Application for approval of details reserved by condition.
Town and Country Planning Act 1990
Planning (Listed Buildings and Conservation Areas) Act 1990

9 No. dwellings with associated car parking, bin storage & landscaping & creation of new access road from existing access onto West Walberton Lane. This application is a Departure from the Development Plan.

Planning Ref: WA/75/17/PL

Amended layout plan showing a change of orientation of pond and details of amended headwalls and wingwalls.

SIMPLE HEADWALL ELEVATION (INLET)
As built site photo for information

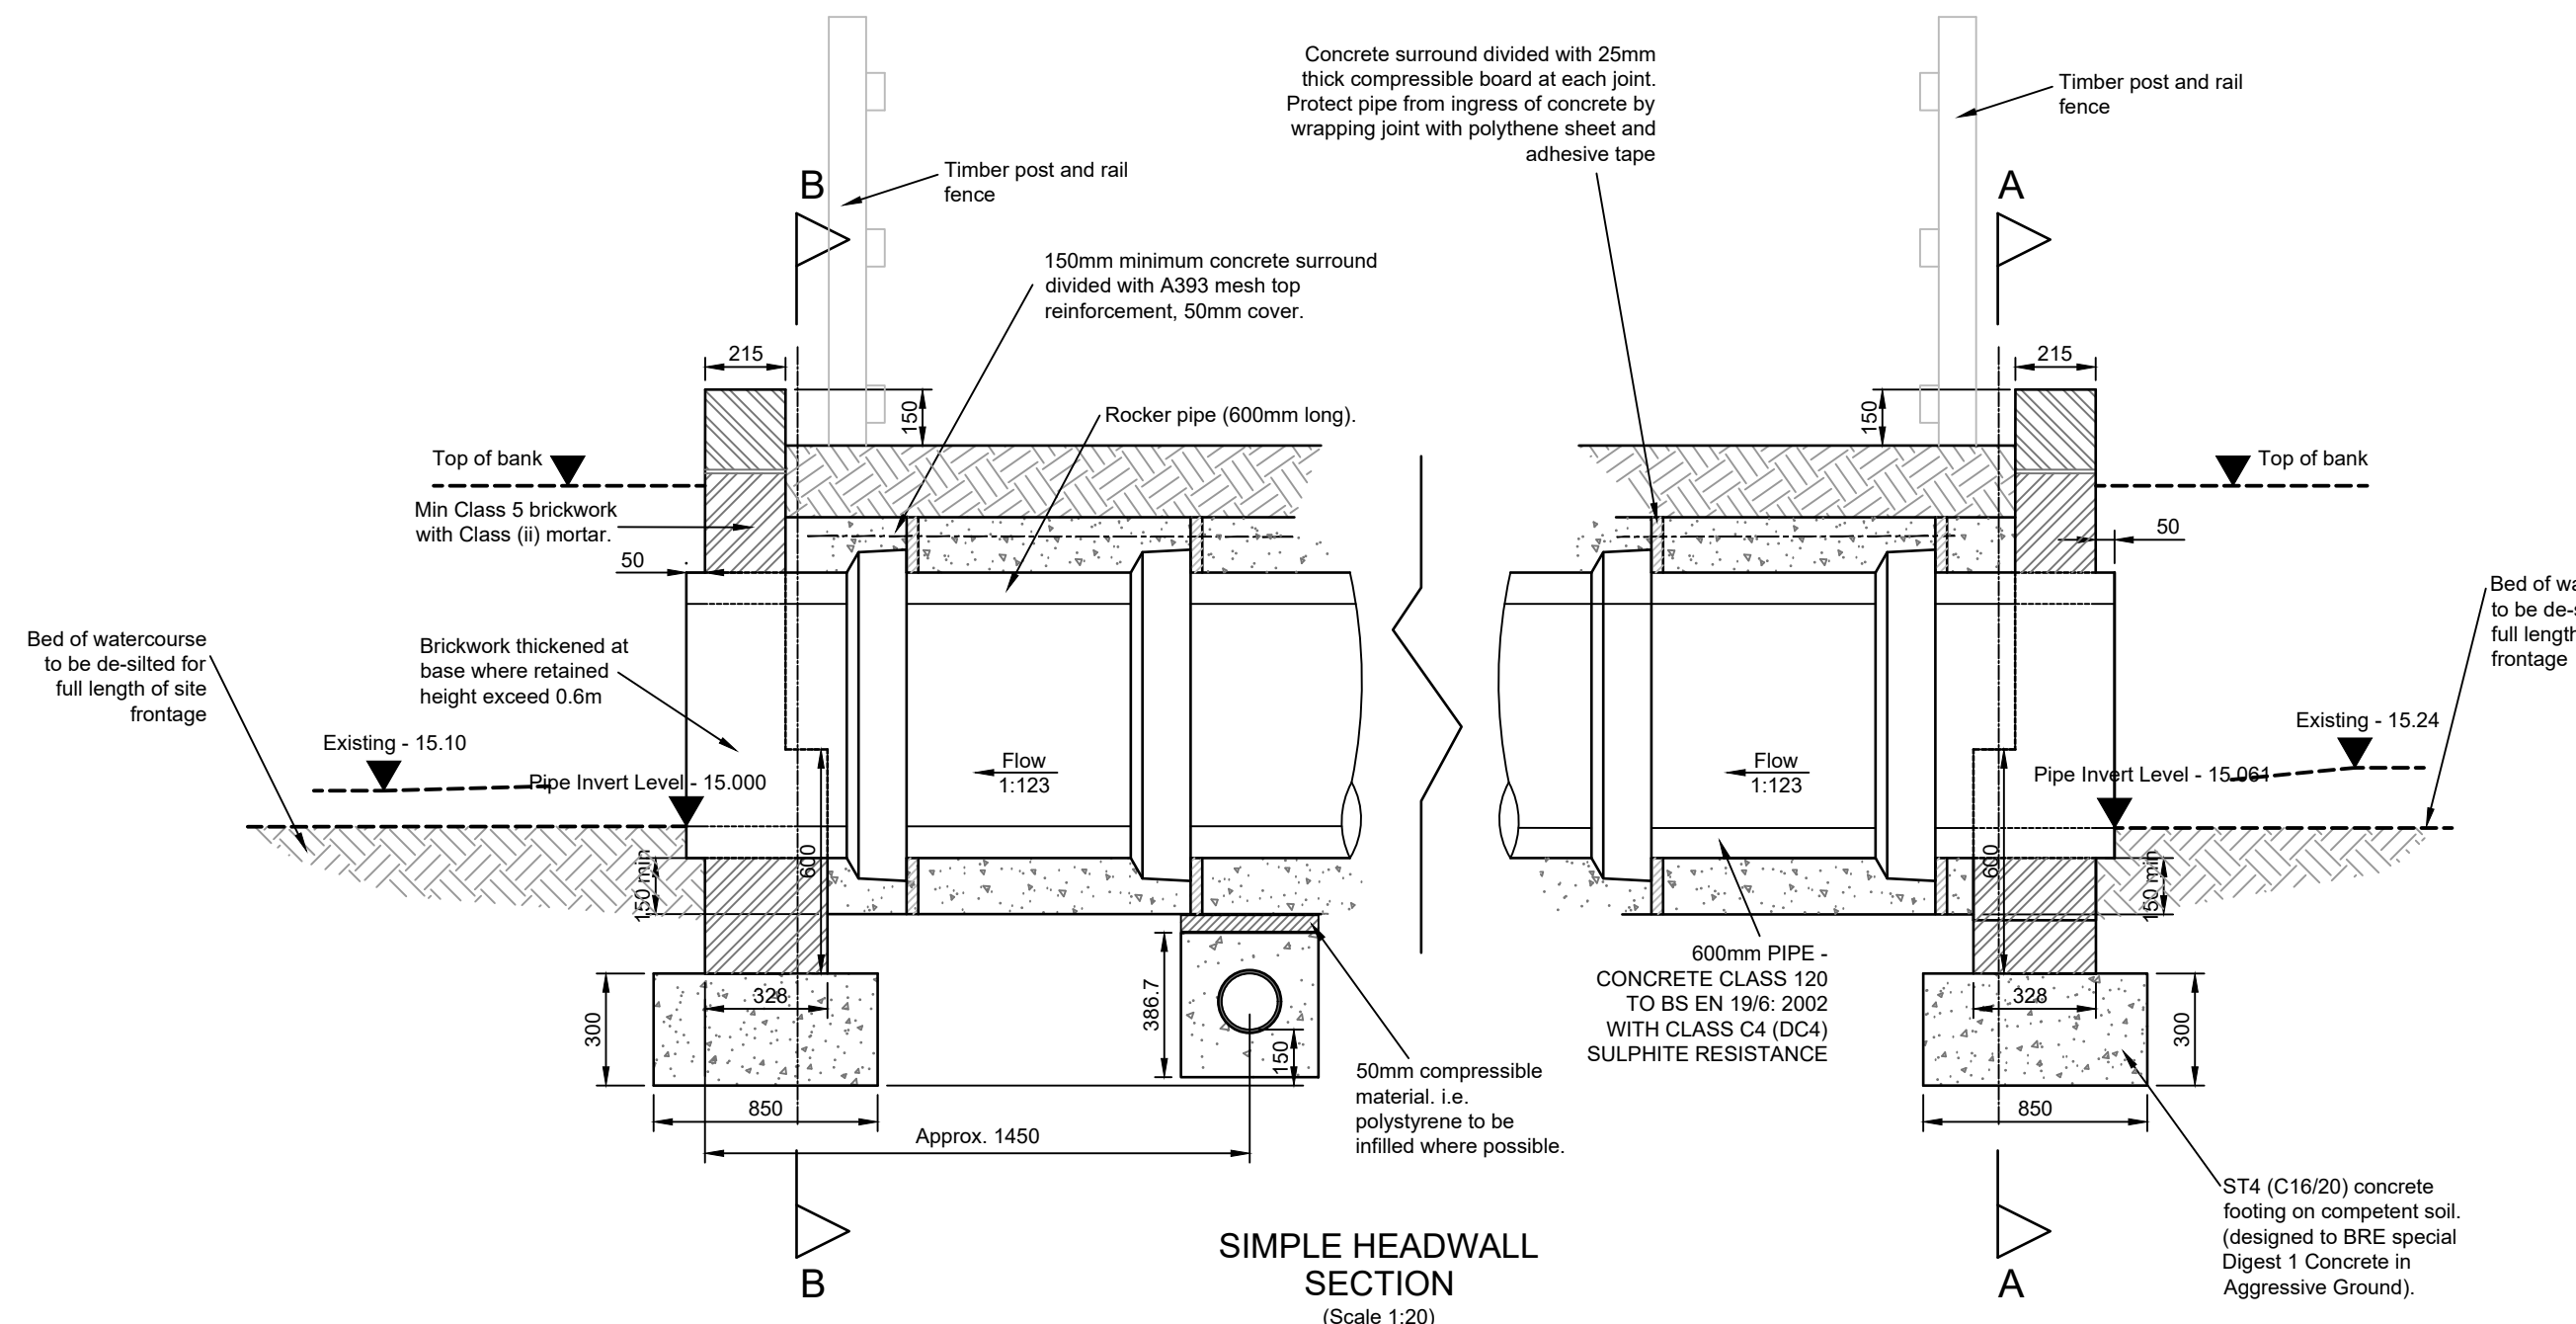
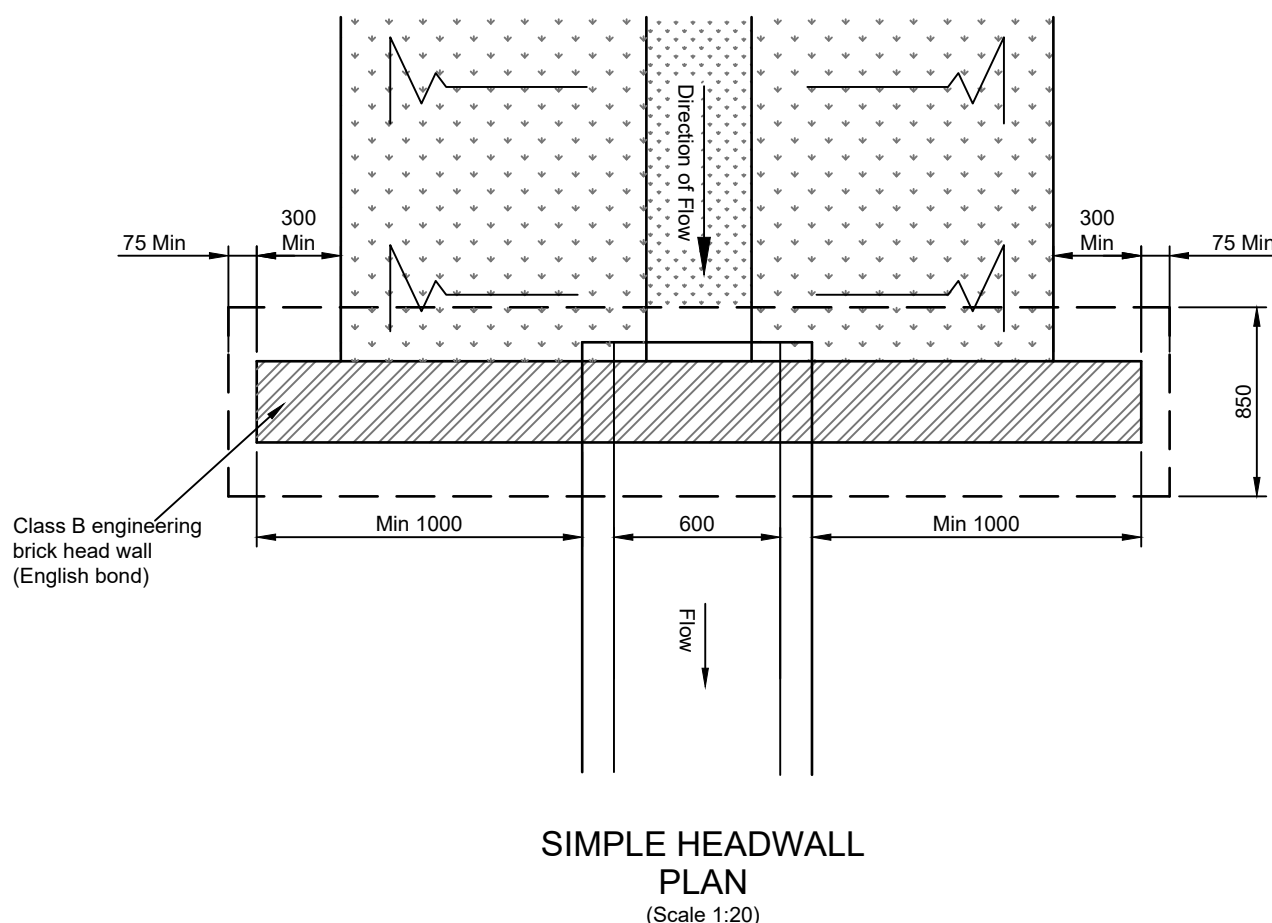
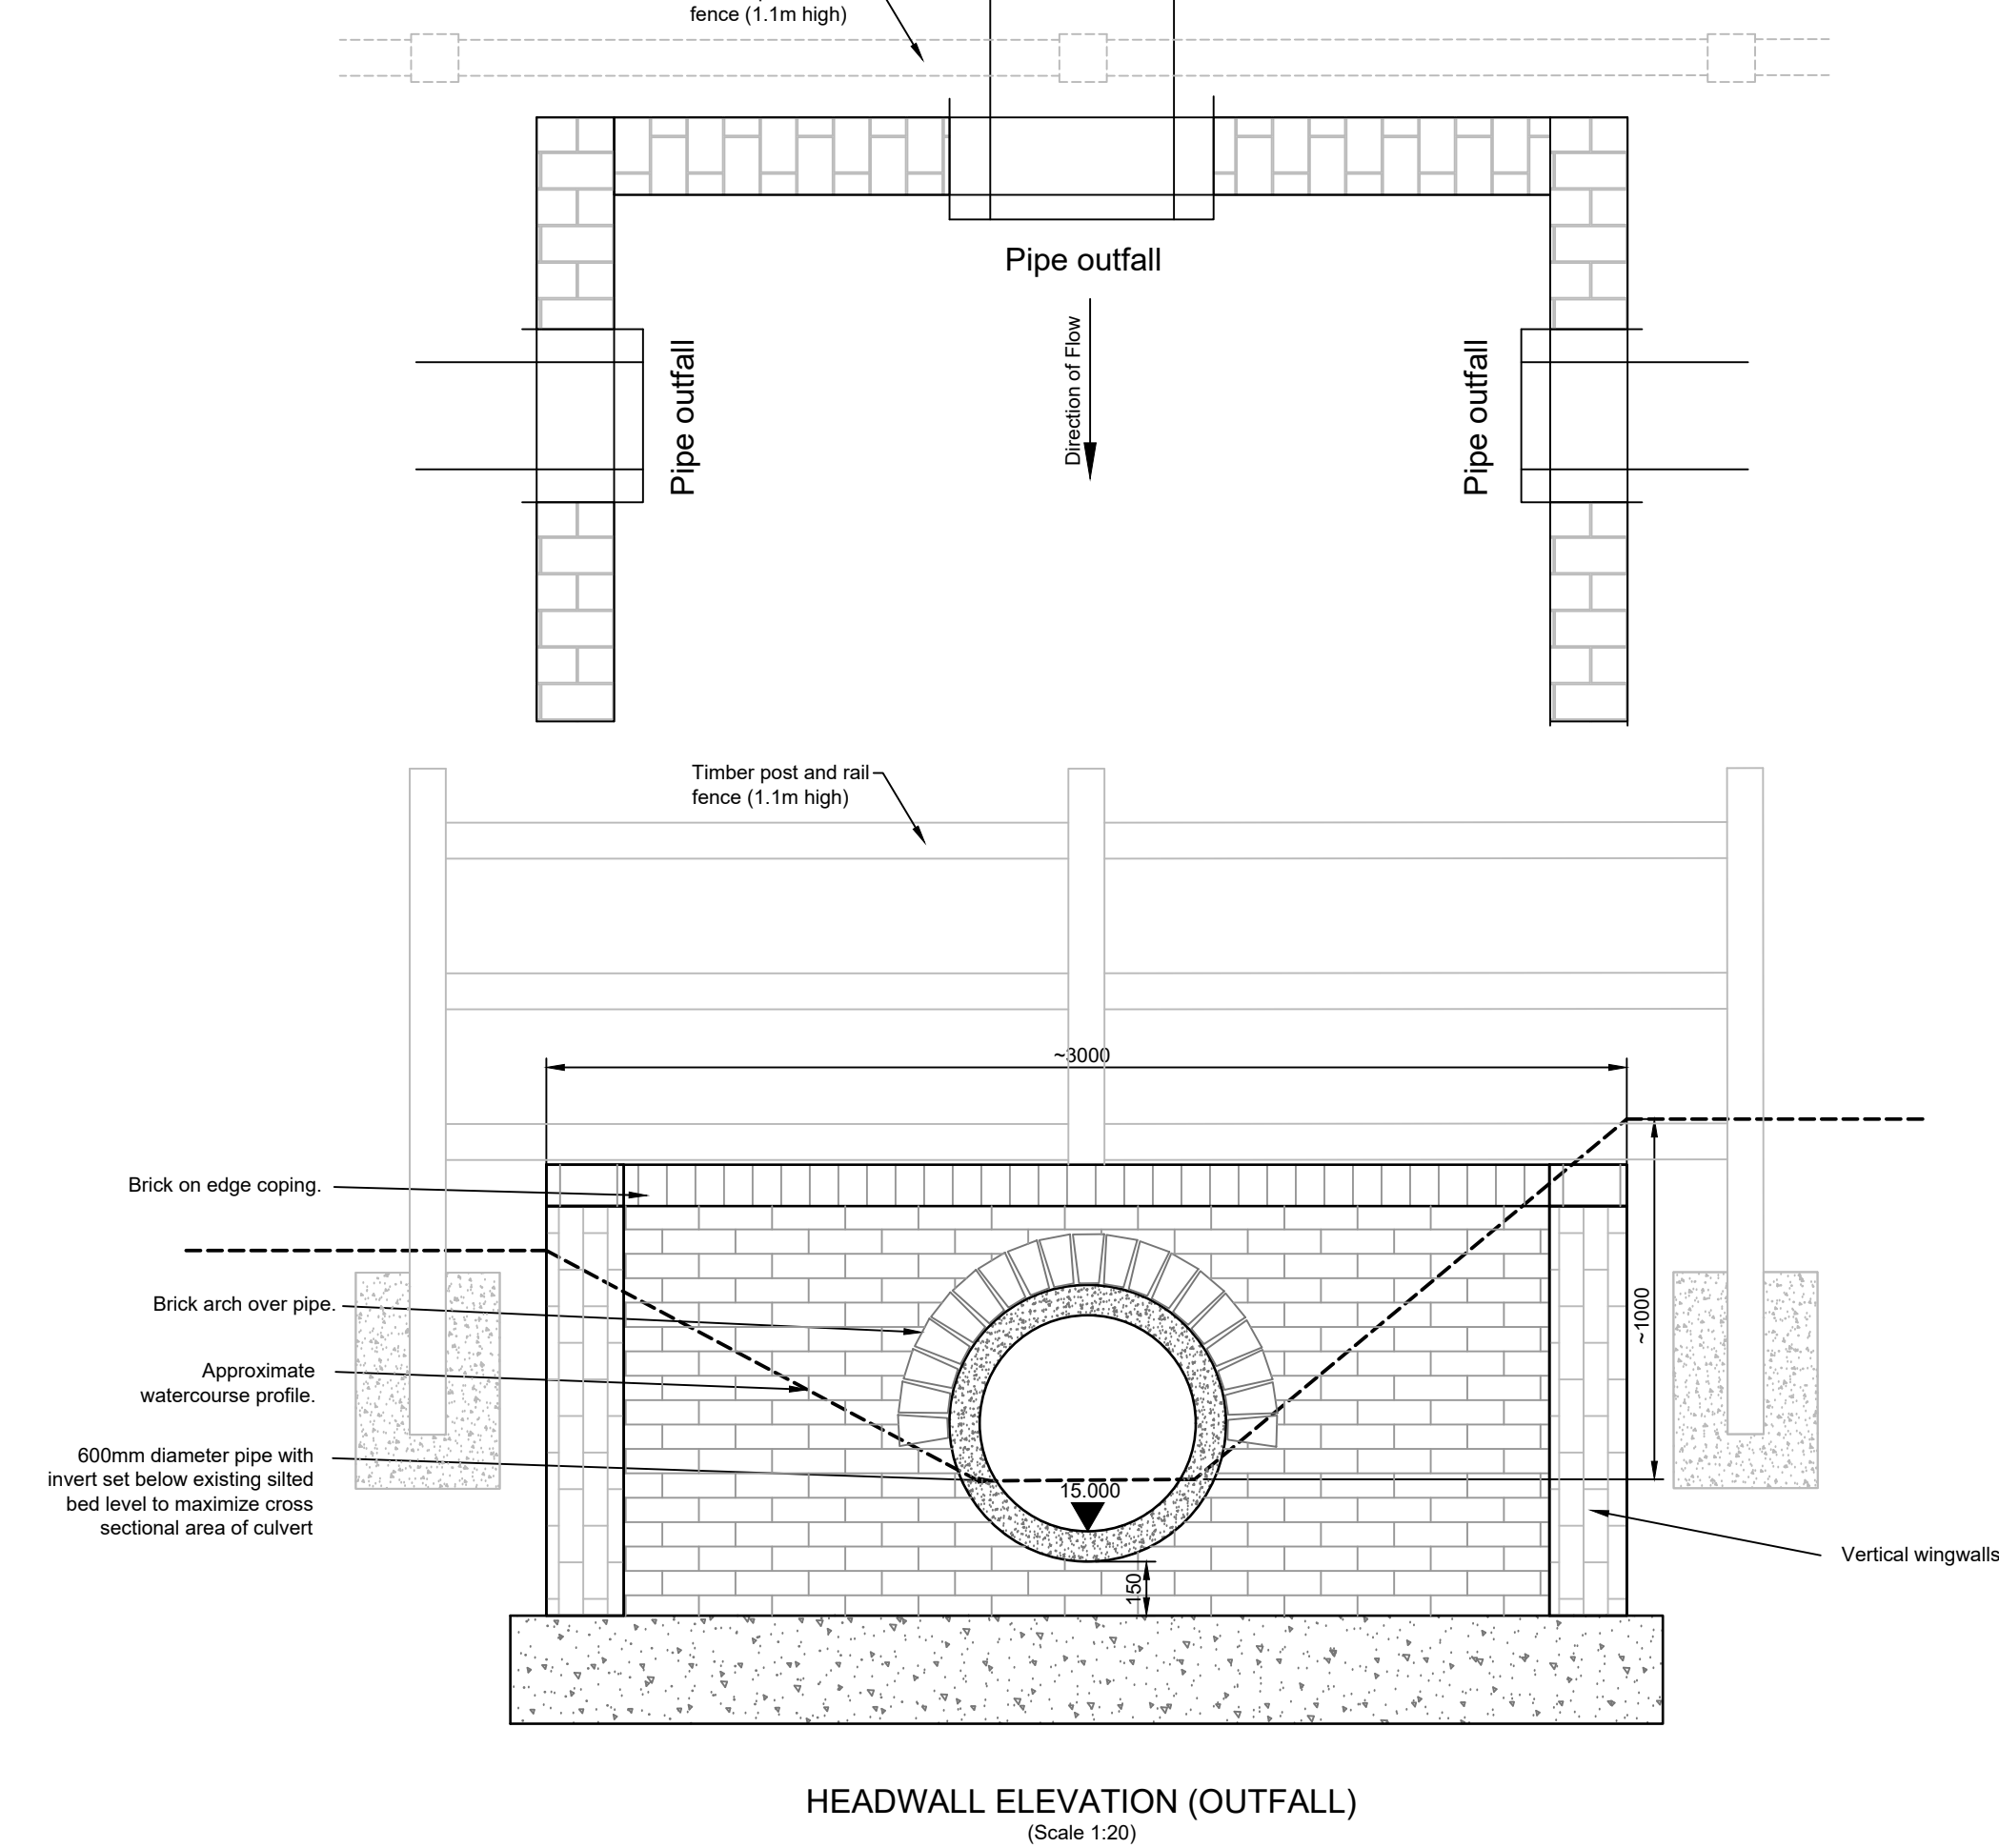
Does the upstream headwall on the culvert also now have splayed wing walls? Please include on drawing if so.
